Application for a non-material amendment following a grant of planning permission.
Town and Country Planning Act 1990

Erection of Detached Garage with Office Above

DC/23/00460

NORTH WEST ELEVATIONS 1:100

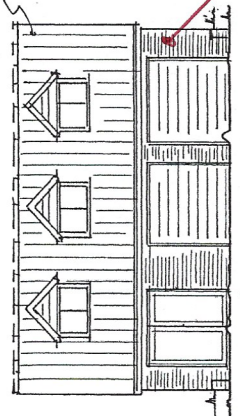
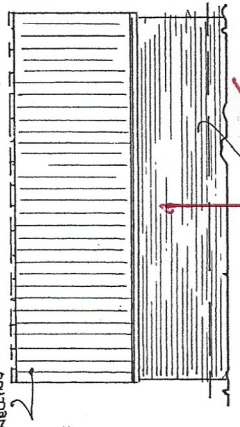
Change from brickwork external wall finish to render to match the main dwelling.
